**CITY OF ALBUQUERQUE  
PLANNING DEPARTMENT  
June 20, 2012  
DRB Comments**

**PROJECT # 1009296**

**APPLICATION # 12-70164**

**RE: Lots 9-11, La Resolana Subdivision**

Sketch Plat Lot 11-A

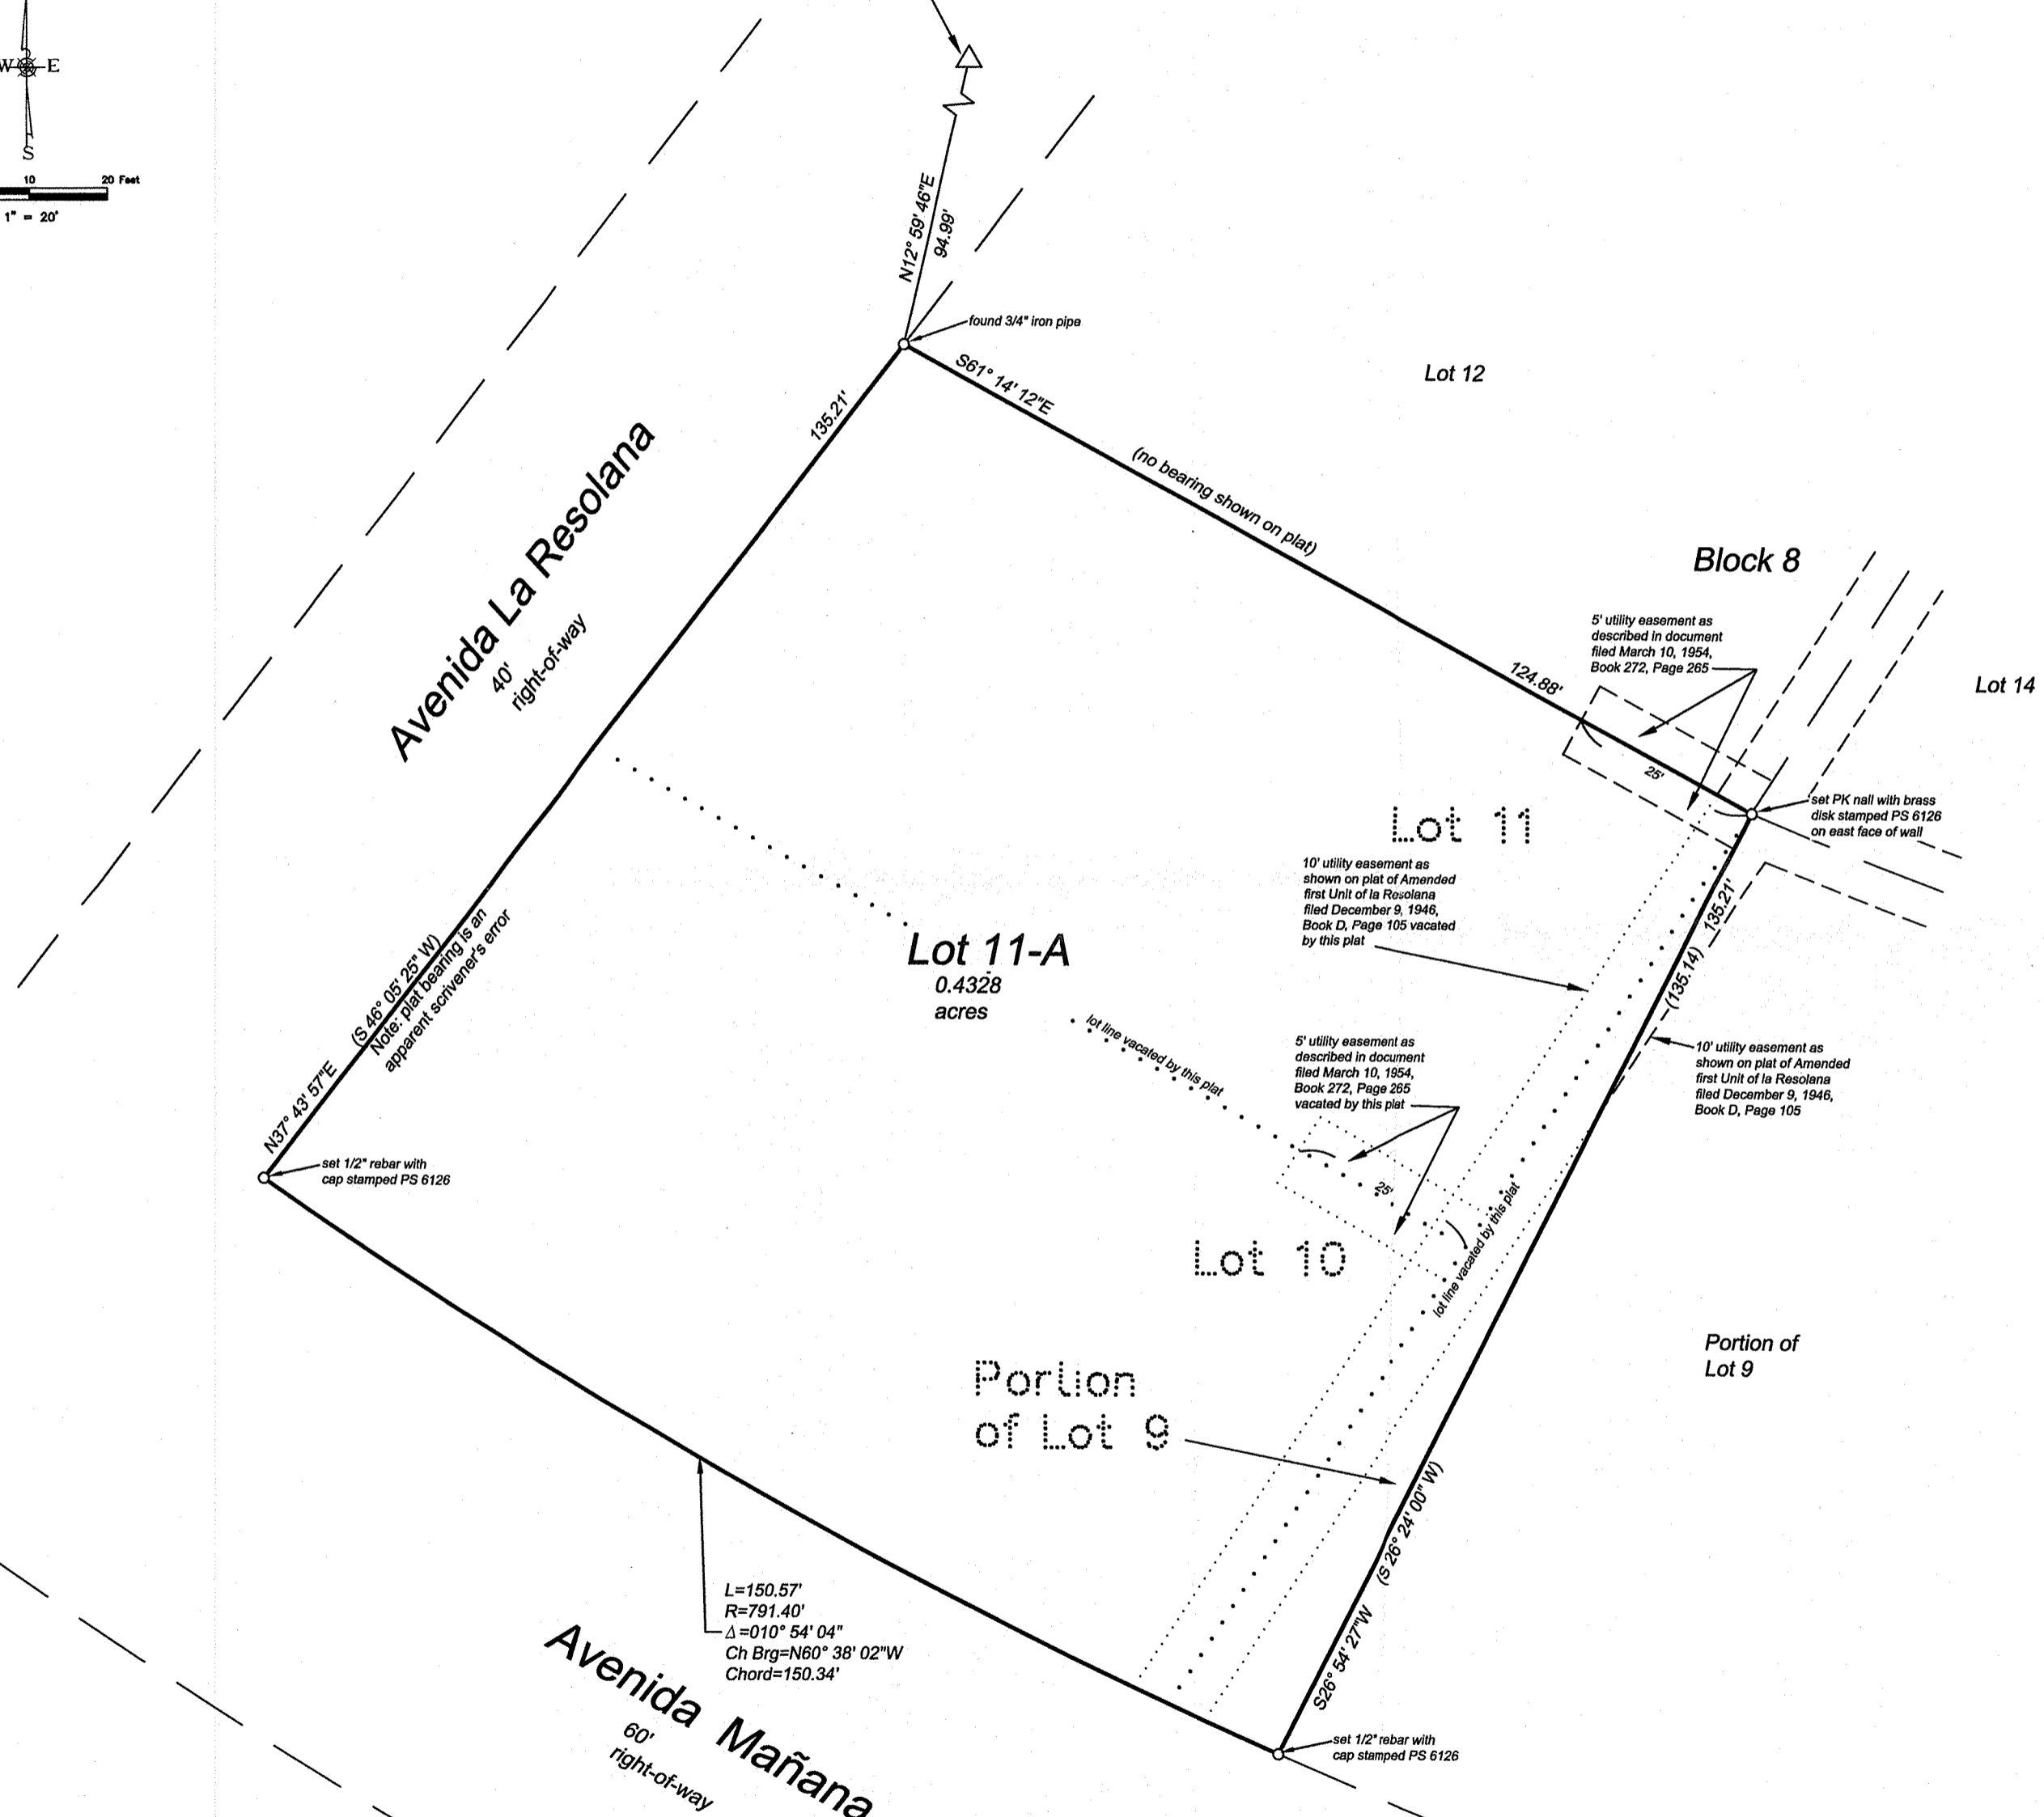
The creation of "Portions of" Lot 9 must be demonstrated by deed dated prior to 1973 to show that property was not transferred in violation of the current Subdivision Ordinance.

The 5 foot easements created by document filed March 10, 1954 can be vacated without a public hearing provided the beneficiaries agree to the vacation in writing; they could also be released by recording a separate document, in which case they would not need to be shown on the plat nor would a separate vacation action and fee be required.

The 10 foot Utility Easement that was shown on the plat would require a vacation application and fee with an advertised public hearing.
